Broad Oak Farm

Changes to House Type Variants following Client's internal layout changes

Side Elevation Plot 47

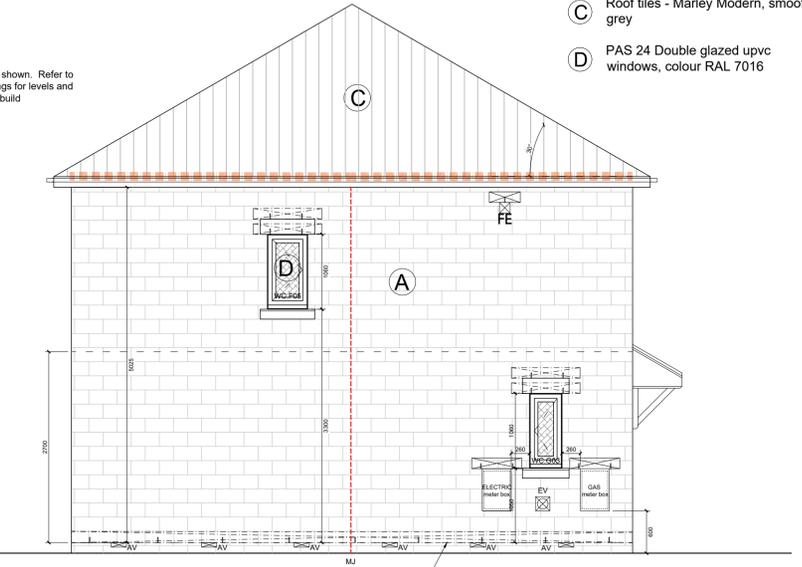
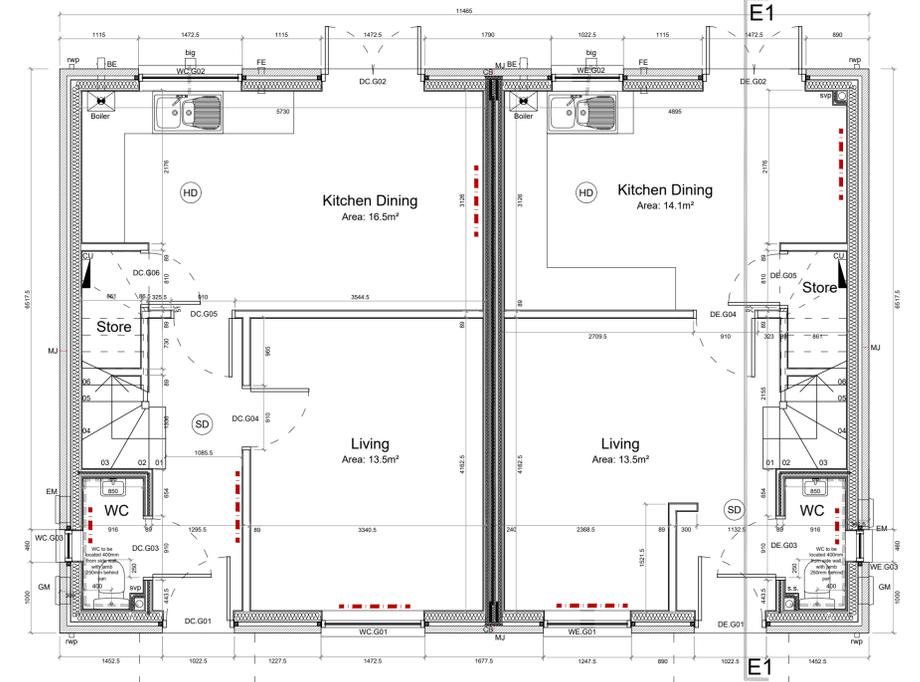
Comments – the gable variant agreed at planning for this plot had four windows in the gable elevation, together with two window blanks. The four windows served the GF WC, kitchen, stair landing and back bedroom. The layout changes agreed by NMA mean that the positions of the WC and landing windows are now offset. It is also no longer possible to provide a window to the kitchen. A window could be provided to the back bedroom, but this may compromise furniture layouts. It would not be appropriate to provide a window over the bath. It is therefore proposed to leave this elevation with just two windows. In this respect it should be noted that the property gives onto a drainage route and that large parts of the side elevation will be concealed by a retaining wall and fence

Side Elevation Plot 46

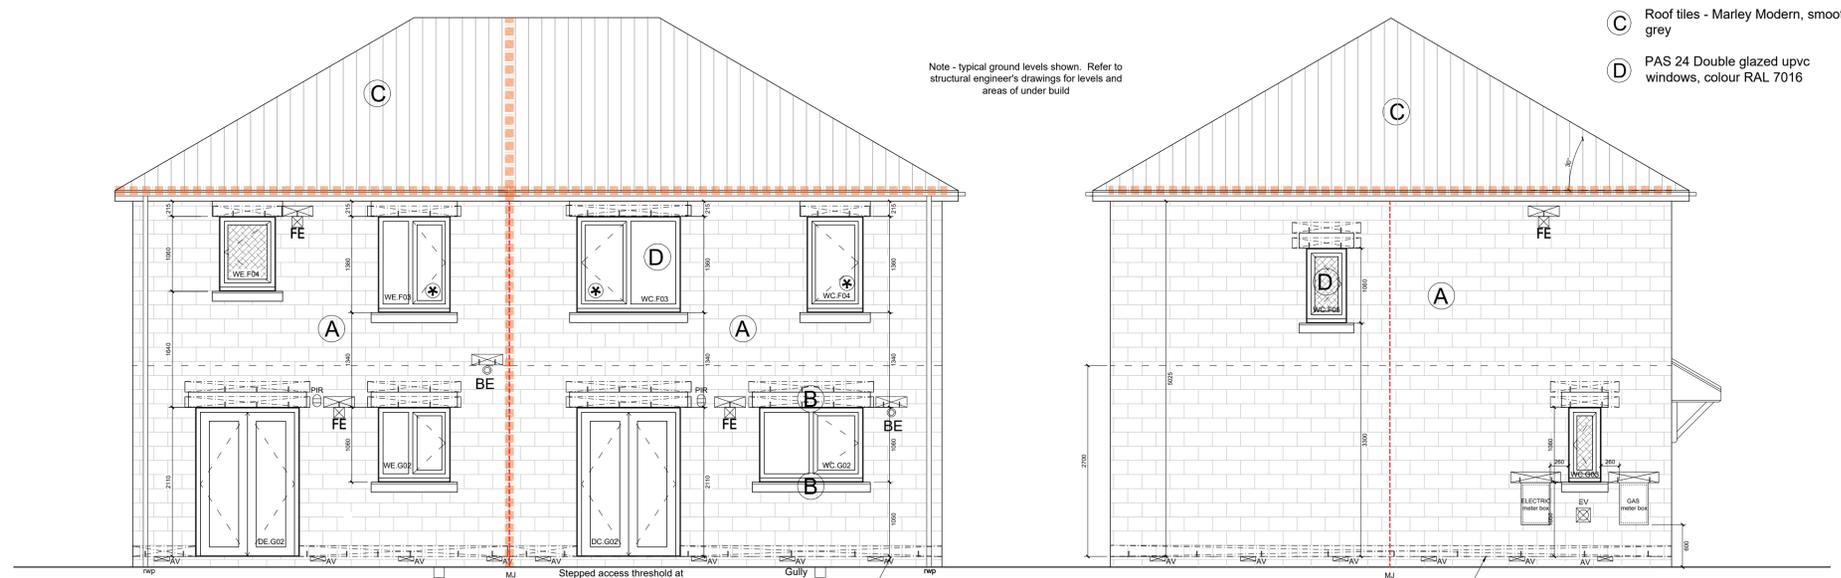
Comments – Revised standard gable elevation for this house type (as approved under NMA) has two windows - GF WC and FF stair. The design originally approved at planning for this plot had five windows in the gable plus one bank window to balance the arrangement, however the internal layout has now changed. The proposed new variant would introduce a further window to the bedroom, however it should be noted that this may compromise the use of the space (wardrobe locations etc). Other planning stage windows have been omitted because the one over the bath would not be appropriate (and as a result any window in kitchen would look odd). Also the window in GF store is not really appropriate.

Side Elevation - Plot 125

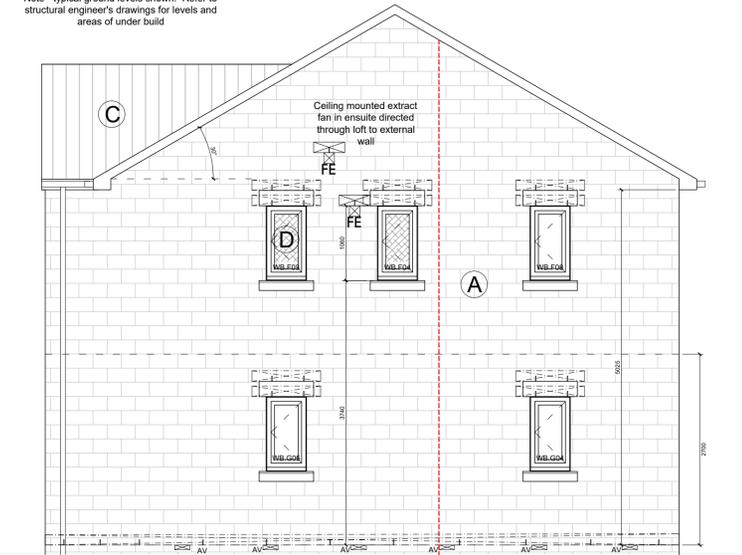
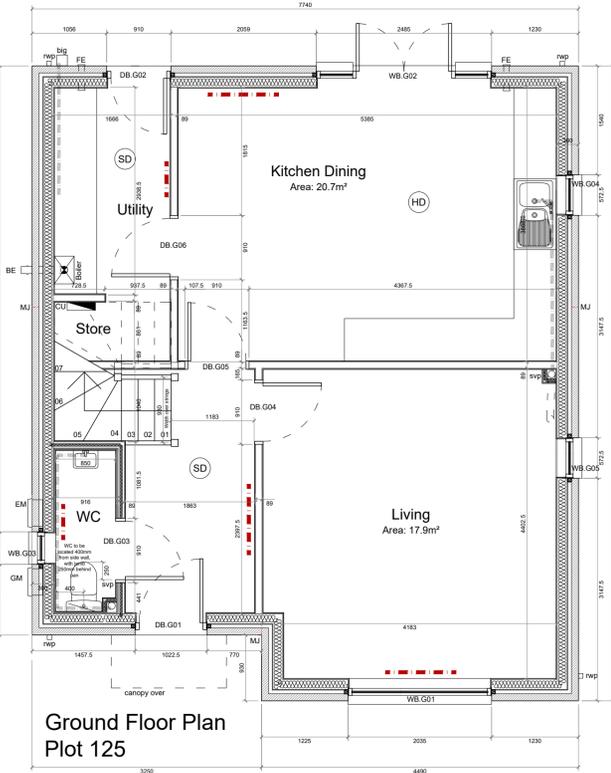
Comments – the standard side elevation for this house type has two first floor windows serving the bathroom and ensuite. The variant originally agreed for this plot introduced three other windows, including a wide kitchen window aligned with the first floor windows above. Changes to the layout have meant that it is no longer possible to align the kitchen window with the upper floor windows (due to clashes with internal walls). Therefore a narrower kitchen window is proposed

Side Elevation - Plot 92

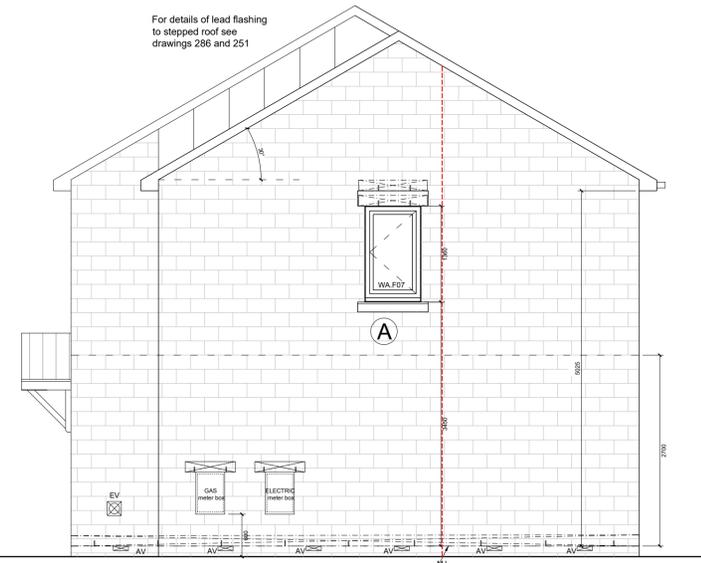
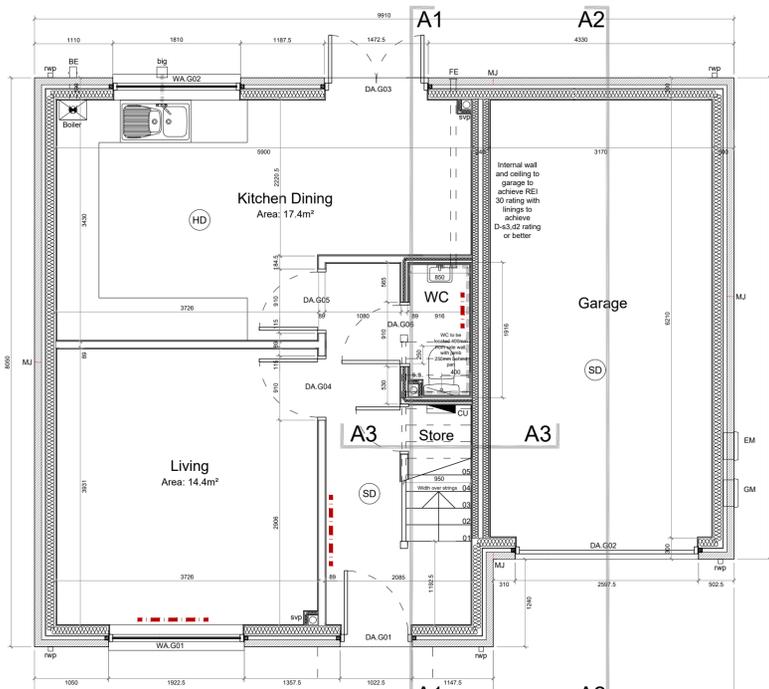
Comments – Standard gable for this house type has no windows. Two gable windows were proposed for this plot at planning (serving a bedroom and en suite). However the internal layout has now changed. It is suggested that the rear bedroom is small and a second window would limit the placement of furniture, therefore it is proposed that this be omitted
